Brian Ramsbottom on behalf of The Swan, Wolfhill, Luggarcurren Wind Aware Group
Tullamoy
Stradbally
Co. Laois
R32 YC57

Re: Proposed Coolglass windfarm and related works
In the townlands of Fossy Upper, Aghoney, Gorreelagh, Knocklead, Scotland, Brennanshill,
Monamantry, Coolglass, Crissard and Kylenebehy, Co. Laois.

Case Reference: PA11.317809

I Brian Ramsbottom, as Chairperson and on behalf of the people of 'The Swan, Wolfhill, Luggarcurren Wind Aware Group, representing approximately 200 families, wish to make the following observations regarding the proposed Coolglass SID Windfarm Development.

Figure 4-2 Wind Energy Map Laois County Council (with Site Location superimposed)

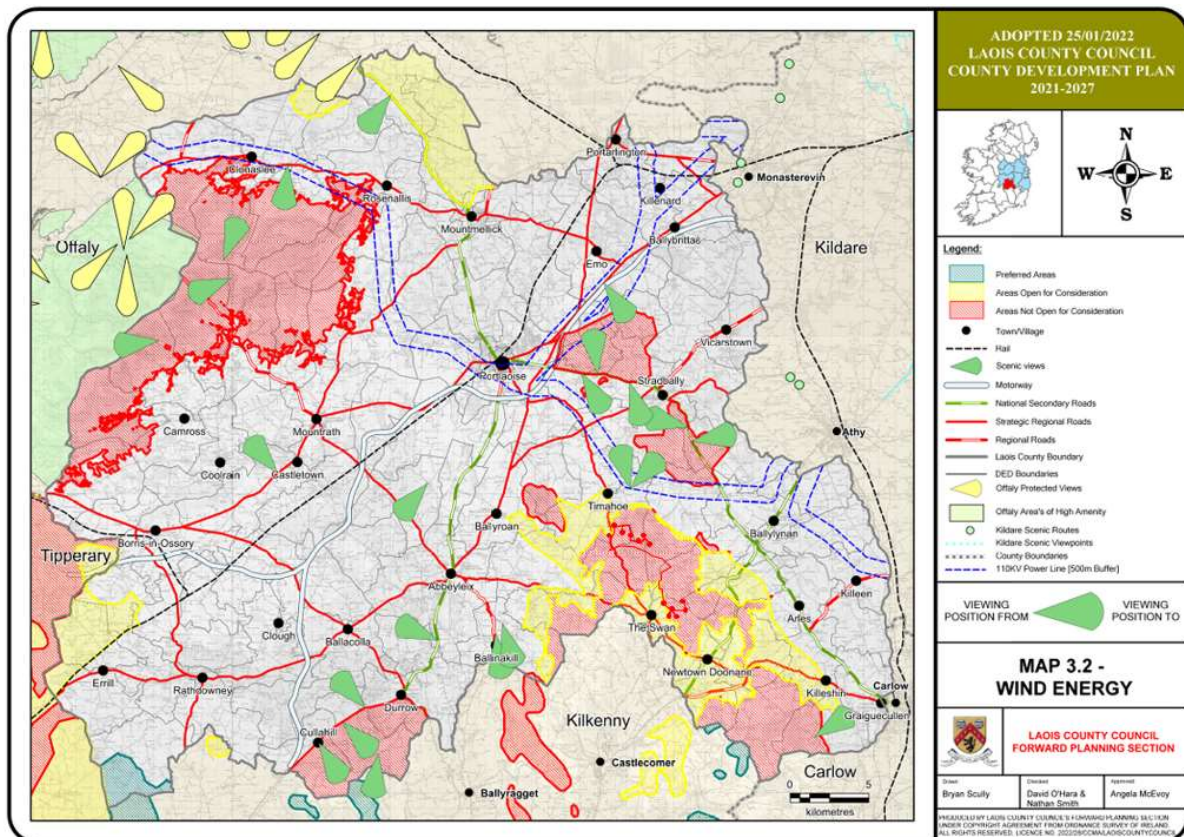
- a. The planning statement in the EIAR states 4 of the southern turbines are within areas 'Open for consideration' for wind energy development. This is incorrect information from the developer. Only one turbine, T11, is in an area 'Open for consideration'. 12 of the 13 proposed turbines are in areas '**Not Open for Consideration**' per appendix 5 Wind Energy Strategy of LCDP 2021 - 2027.
